CITY OF ALBUQUERQUE

Re: 601 Commercial renovation
601 Commercial St. NE Albuquerque NM
Traffic Circulation Layout
Engineer's/Architect's Stamp **04-22-2019** (J14D124)

Based upon the information provided in your submittal received 04-23-2019, the above referenced plan cannot be approved for Building Permit until the following comments are addressed:

TCL-1

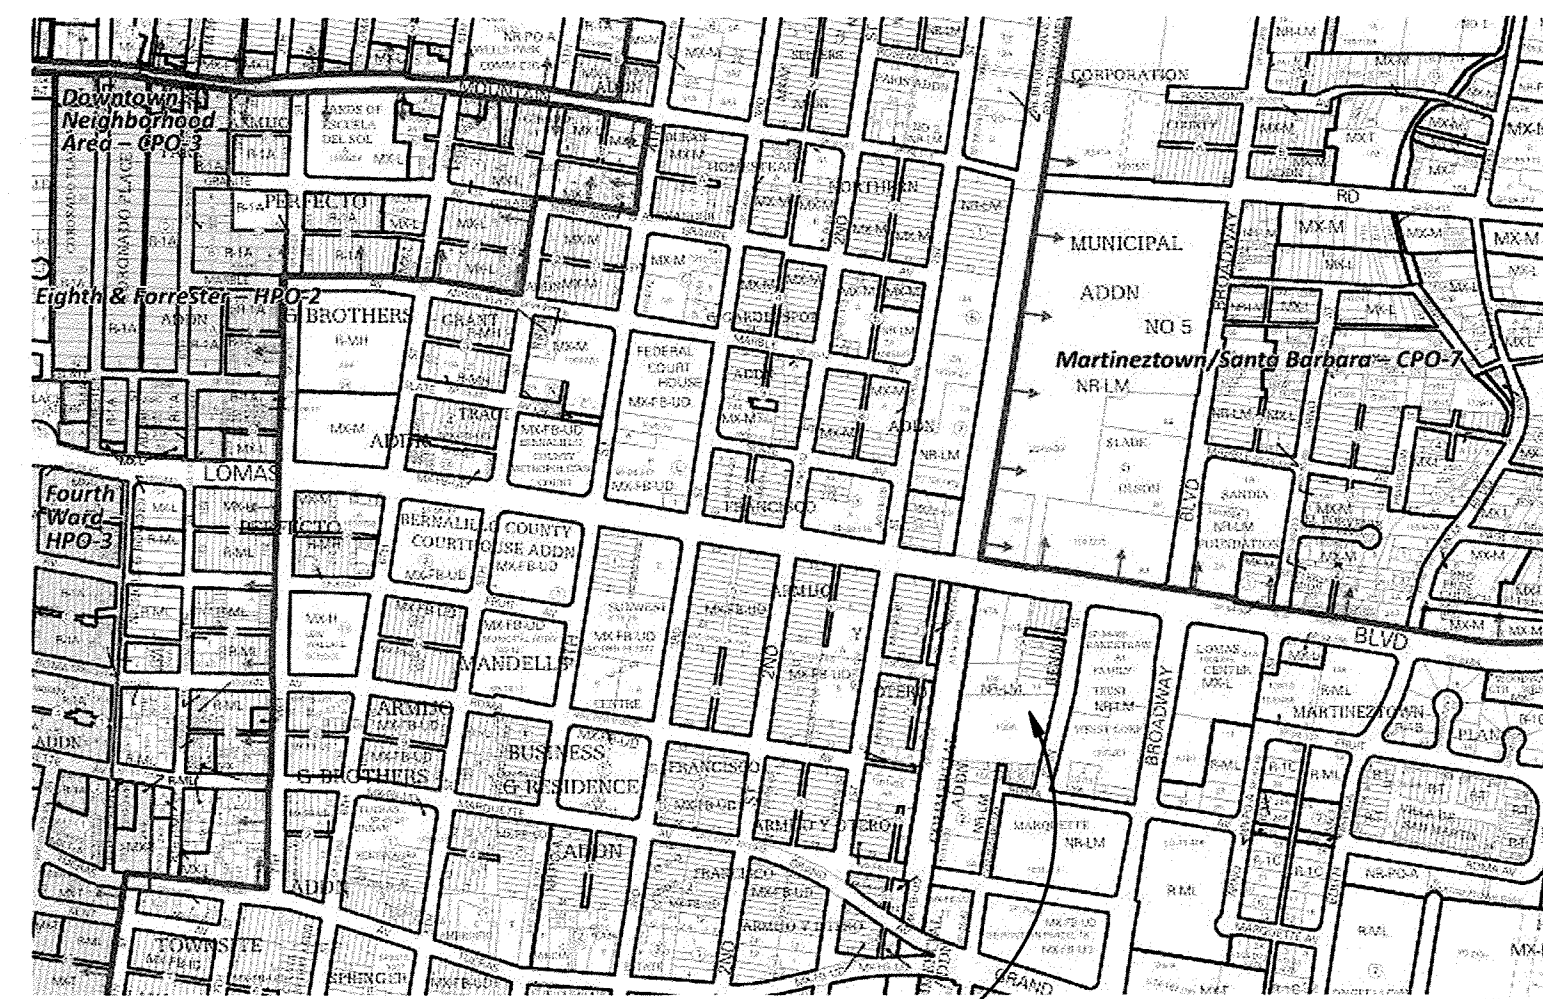
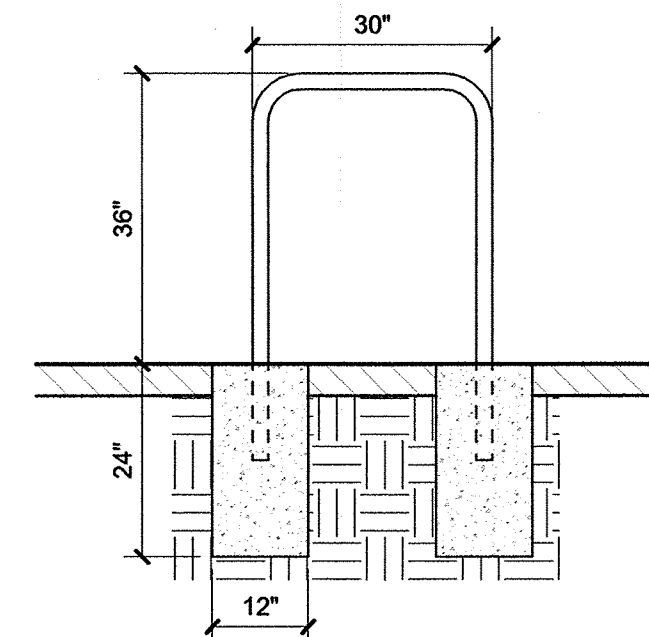
1. Please show the property lines. The property lines shown on AGIS is different than what is partially shown on TCL.
2. The proposed walk-through gates won't work the way it's shown because it is opening into right of way.
3. ADA curb ramps must be updated to current standards and have truncated domes installed.
4. Provide a min 6" or max 8" high concrete barrier curb or other acceptable barrier between landscaping and parking areas and/or drive aisles. Please call out detail and location of barrier curb.
5. Please include a copy of your shared access agreement with the adjacent property owner. The access on Commercial street is providing access to more than one property.
6. Unused curb cuts must be replaced with sidewalk and curb & gutter. A build note must be provided referring to the appropriate City Standard drawing. It seems that 02-0000 G won't be used and needs to be closed.
